SWT17/00012
SF2017/022657

**SSD 8208 - PROPOSED "COLEAMBALLY" SOLAR FARM, LOT 78, 81, 82, 83, 100 & 101
DP750896 & LOT 1 DP821577, KIDMAN WAY, COLEAMBALLY.**

Roads and Maritime Services has reviewed the Environmental Impact Statement (EIS) prepared by NGH Environmental for the Coleambally Solar Farm project. From the information provided it is understood that the proposal is for the establishment and operation of a 150 MW solar photovoltaic (PV) plant and associated infrastructure on the subject site. The subject site has frontage to the Kidman Way, which is a classified road, and to Ercildoune Road within a 100 km/h speed zone. The Kidman Way is an approved road train route.

Proposed Intersection Layout Plan

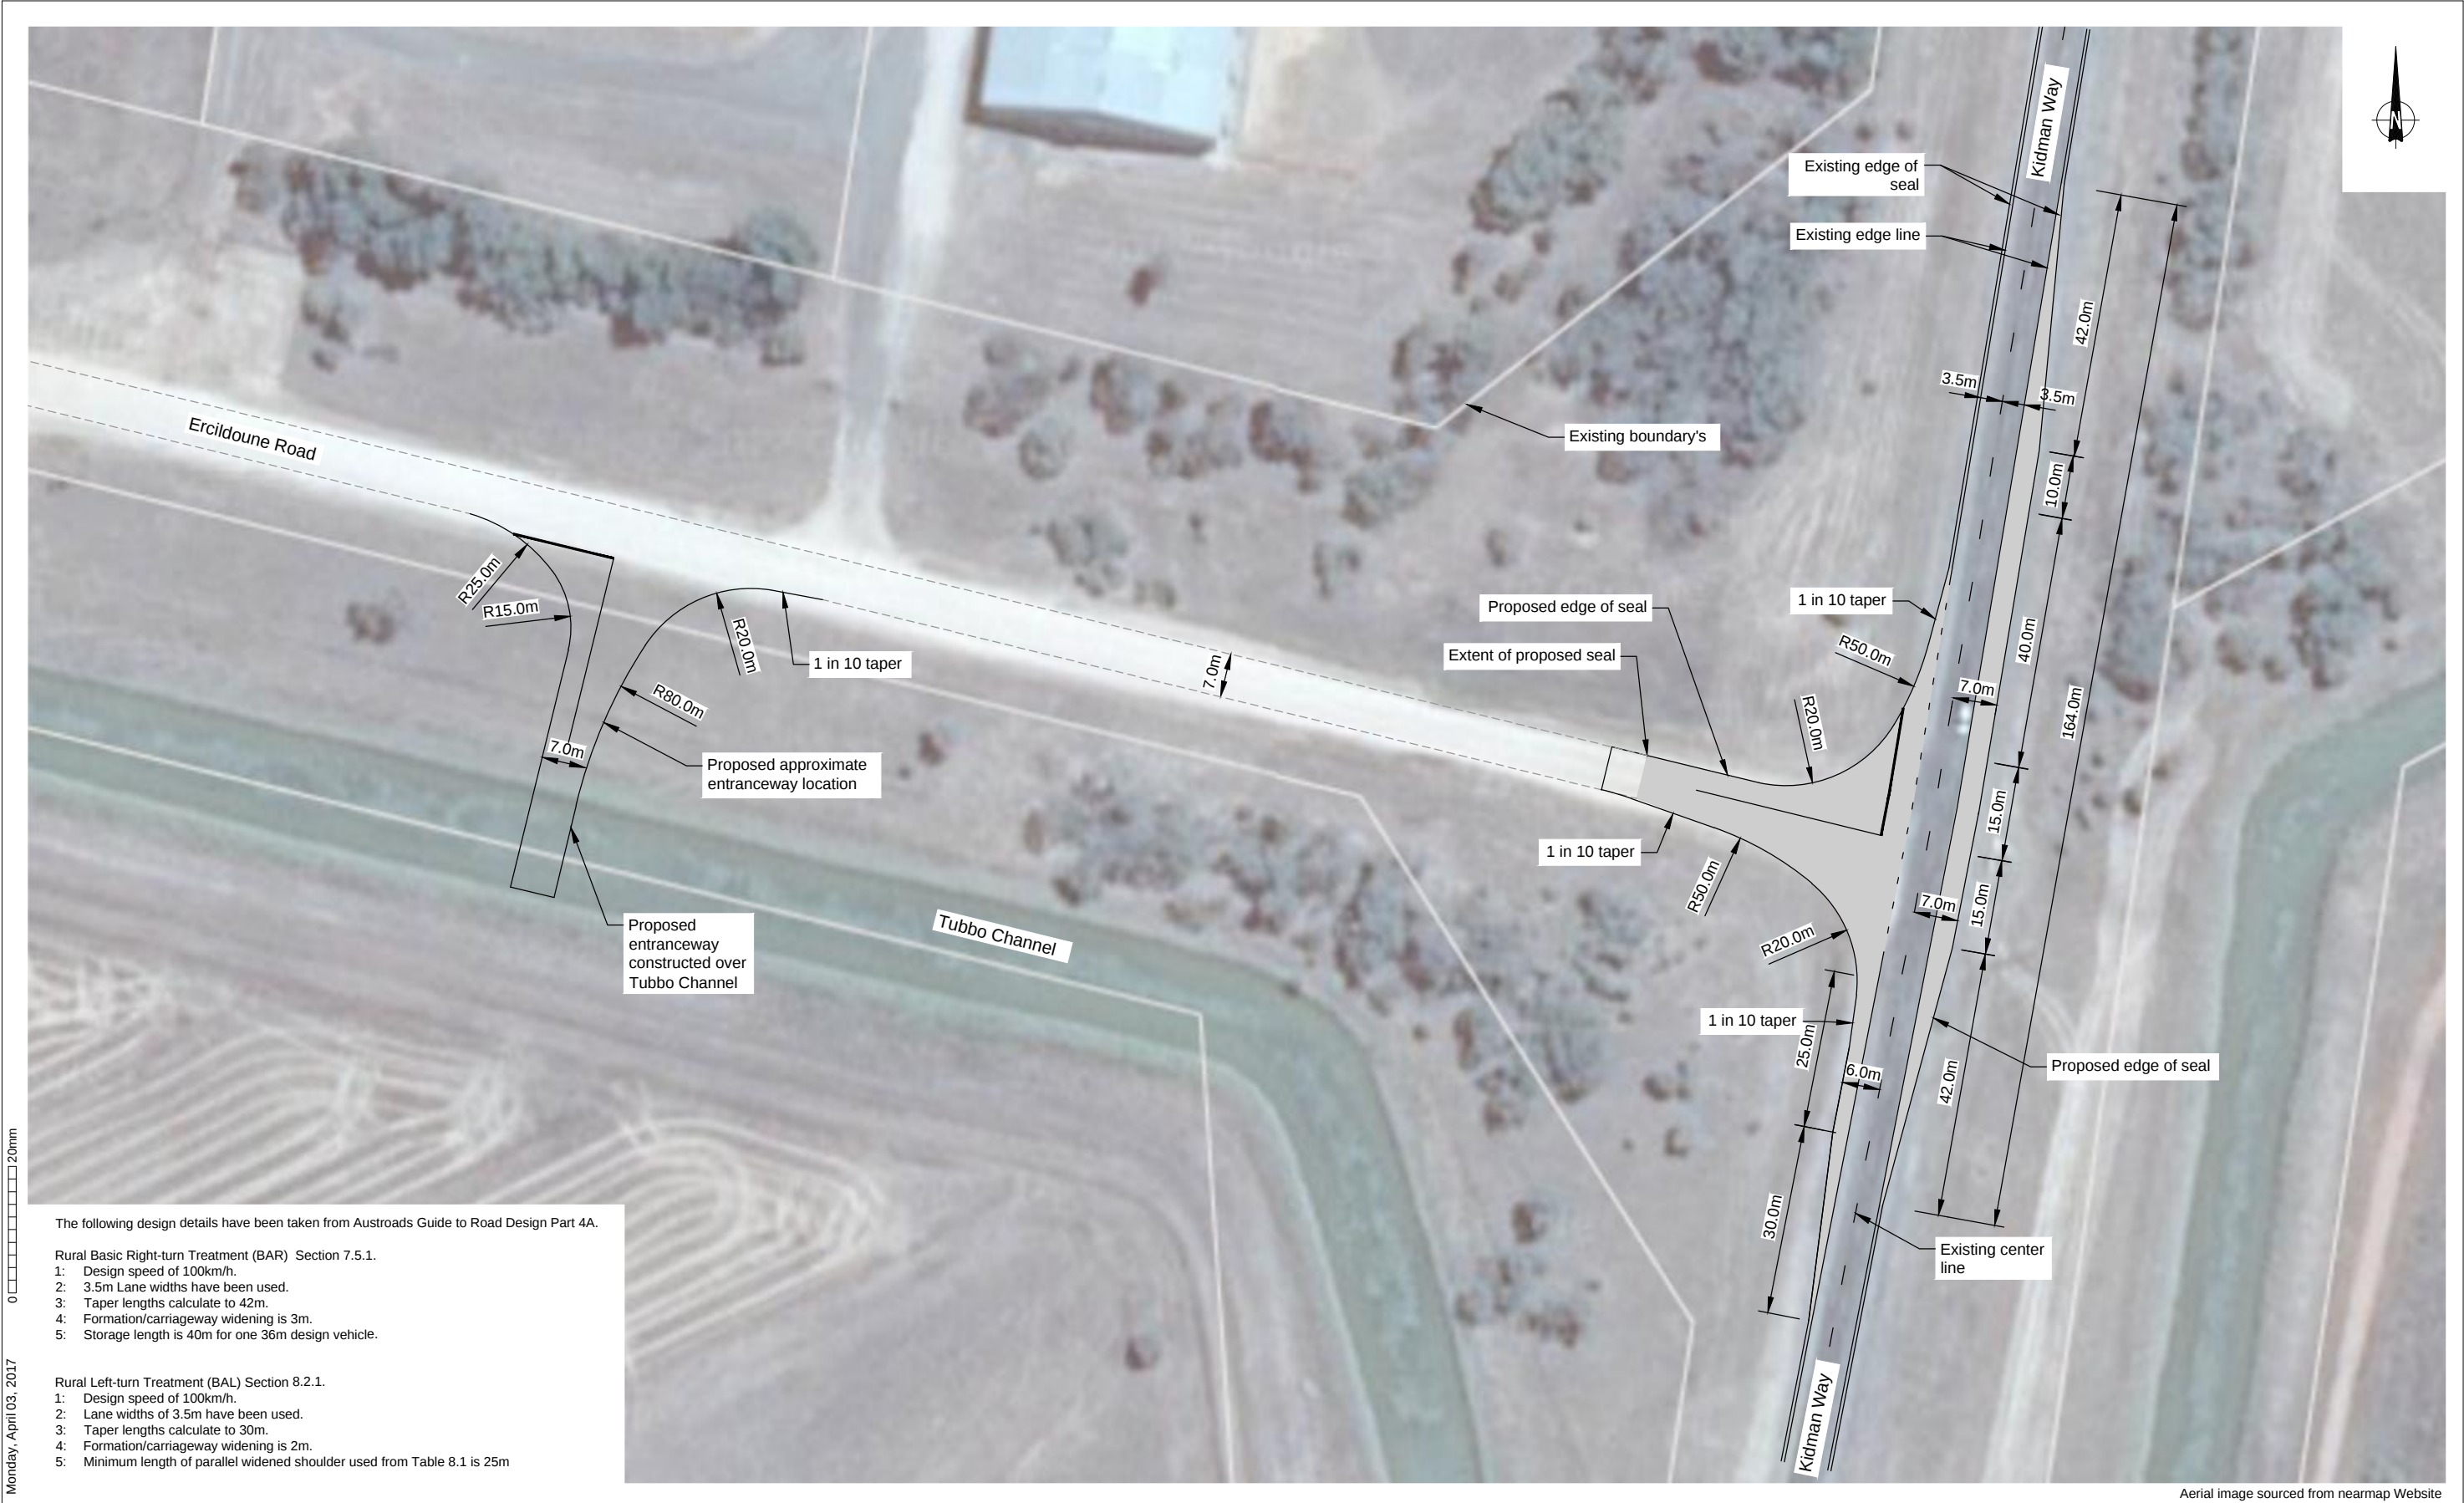
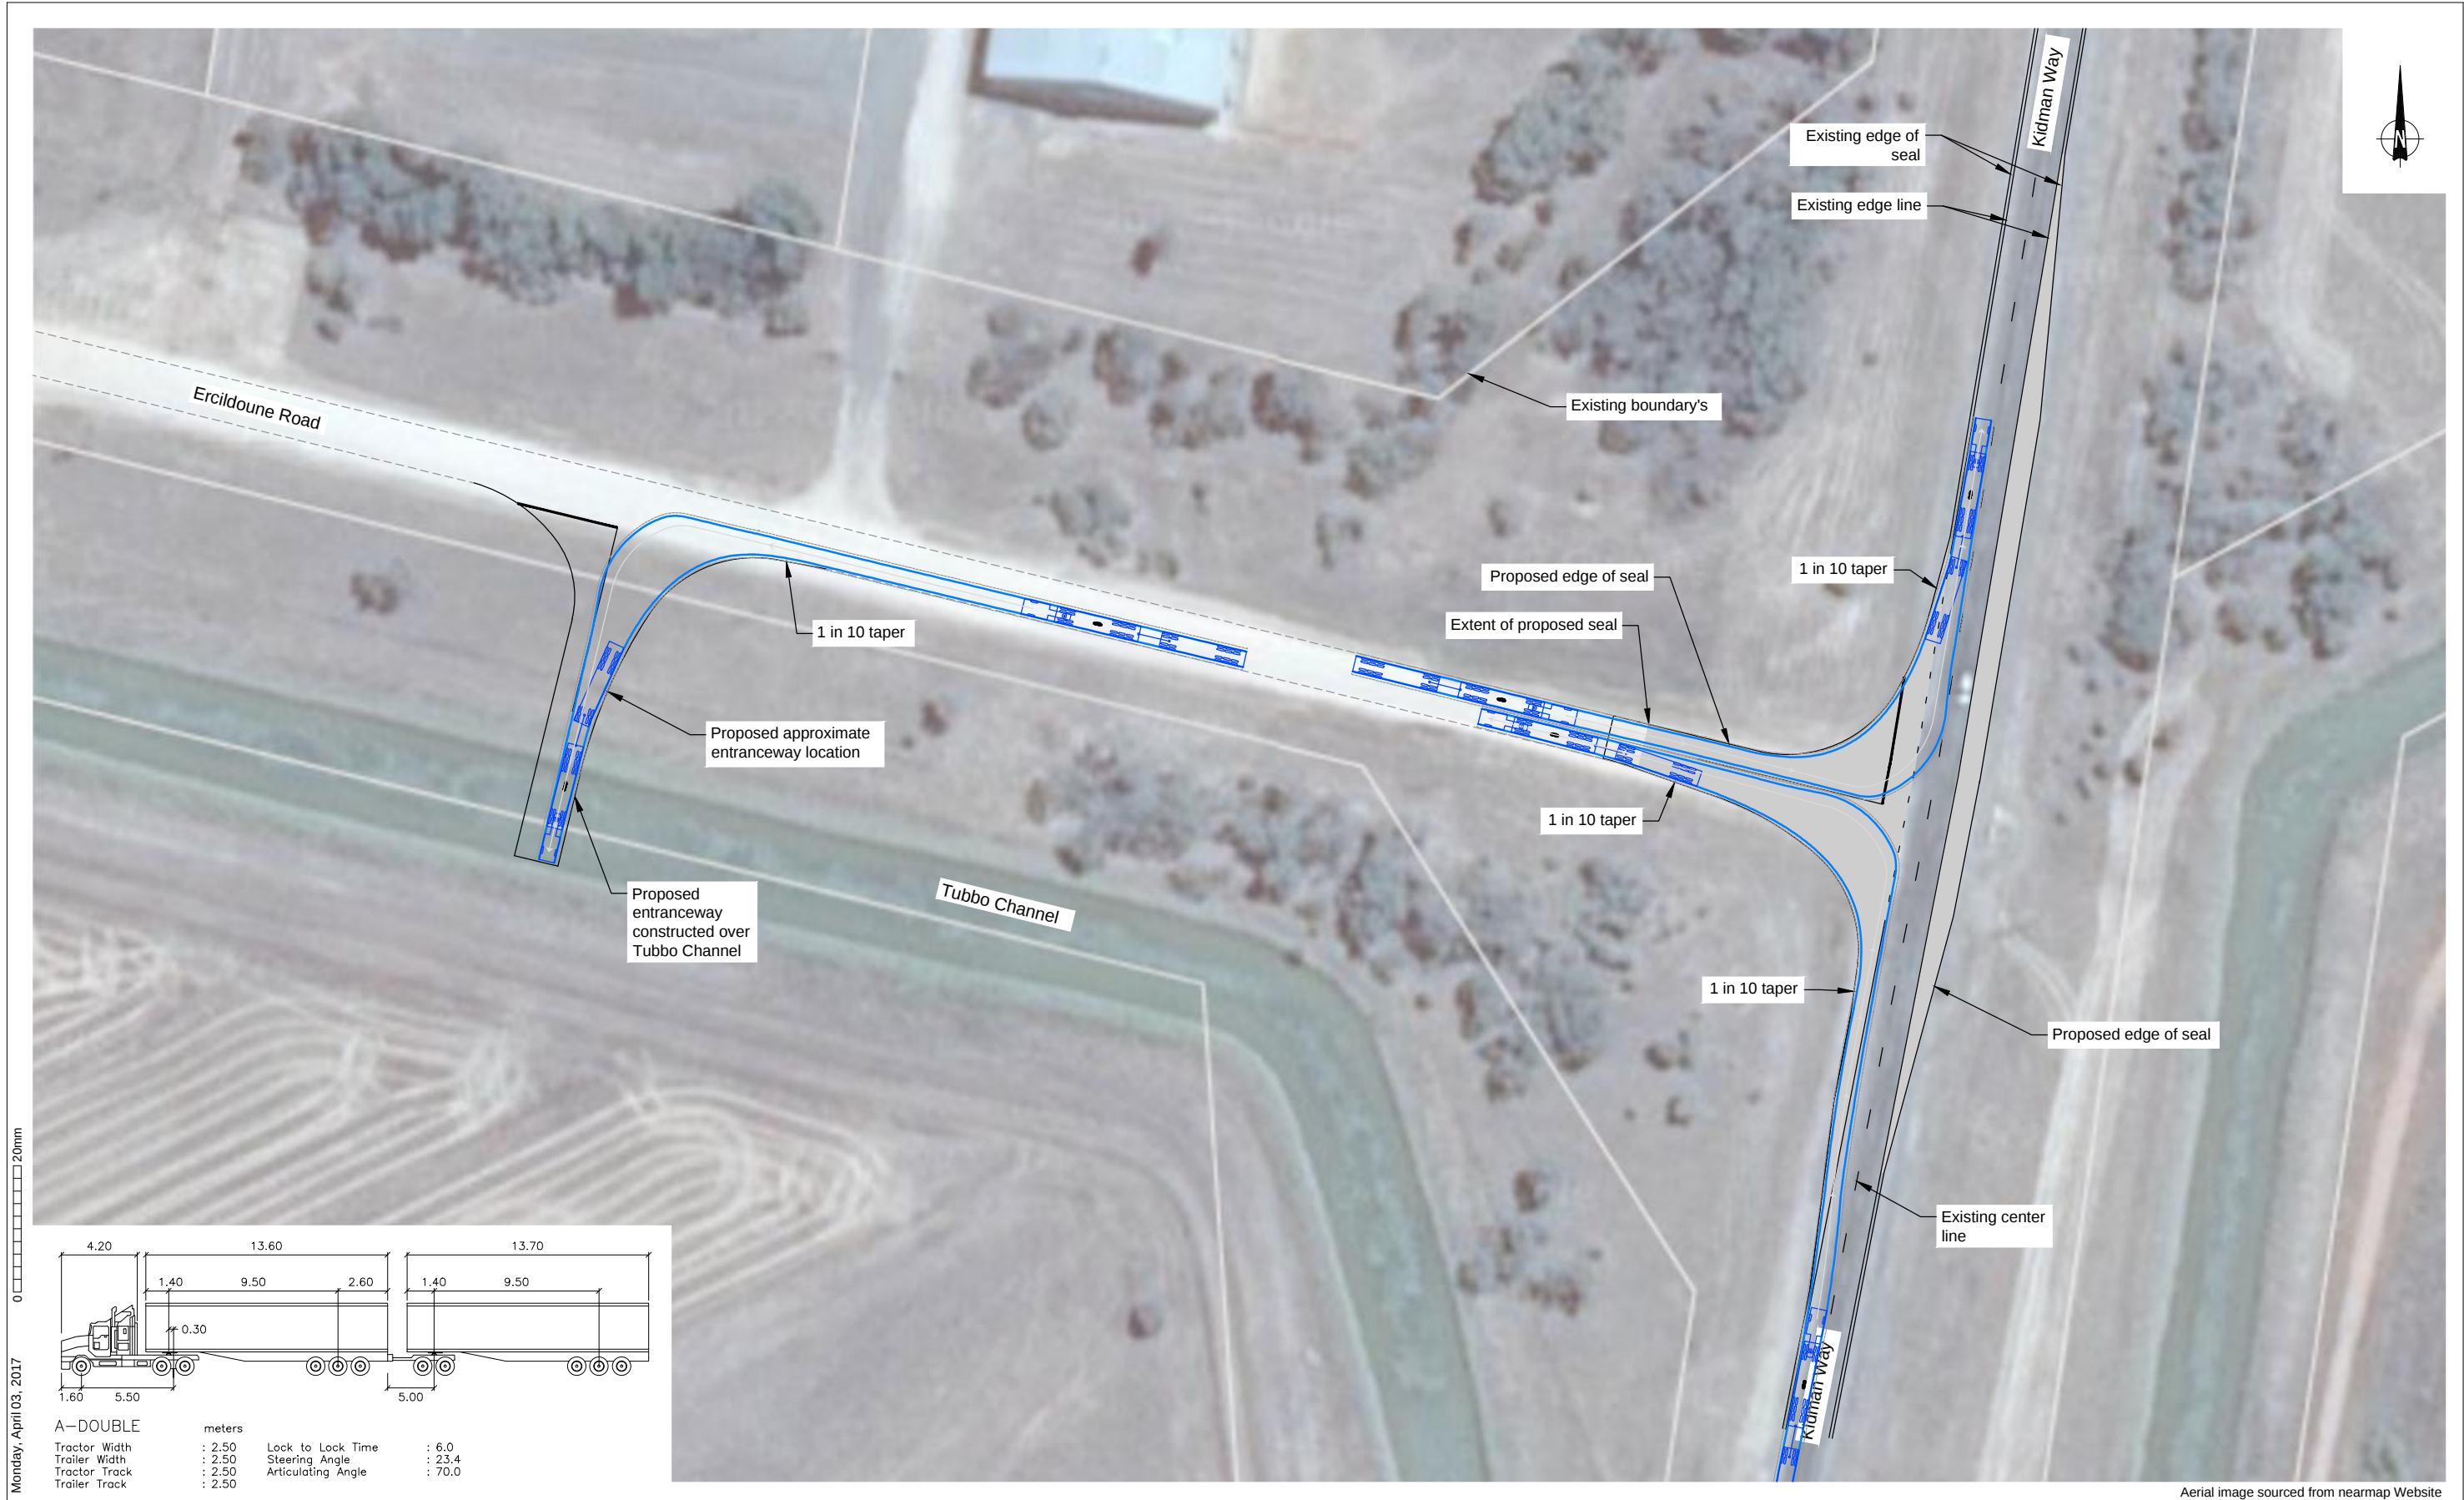
4. As a minimum the intersection of the Kidman Way and Ercildoune Road is to be constructed and the roadside maintained to the satisfaction of Roads and Maritime Services to comply with the following:

- i) Provide for the required Safe Intersection Sight Distance (SISD) with a reaction time of 2.5 seconds in either direction in accordance with the Austroads Publications as amended by the supplements adopted by Roads and Maritime Services for the posted speed limit. Compliance with this requirement is to be certified by an appropriately qualified person prior to construction of the vehicular access.

- ii) Constructed with a Basic Right Turn (BAR) and Basic Left Turn (BAL) intersection treatment in accordance with the Austroads Guide to Road Design as amended by the supplements adopted by Roads and Maritime Services for the posted speed limit on the Kidman Way. The intersection is to be constructed to the standards required for an approved road train route.

- iii) Designed and constructed so as not to interfere with the capacity of the current roadside drainage network and to prevent water from proceeding onto, or ponding within, the carriageway of the Kidman Way. If a culvert is to be installed and is to be located within the required clear zone of the Kidman Way for the posted speed zone it is to be constructed with a traversable type headwall.

- iv) The construction of Ercildoune Road to 2 lanes and be sealed for at least 50 metres from its intersection with the Kidman Way. The intersection shall be designed and constructed so that vehicles turning between the Kidman Way and the access road are not required to cross to the opposing travel lane in order to perform a turn manoeuvre. The intersection shall be line marked in accordance with Australian standards.
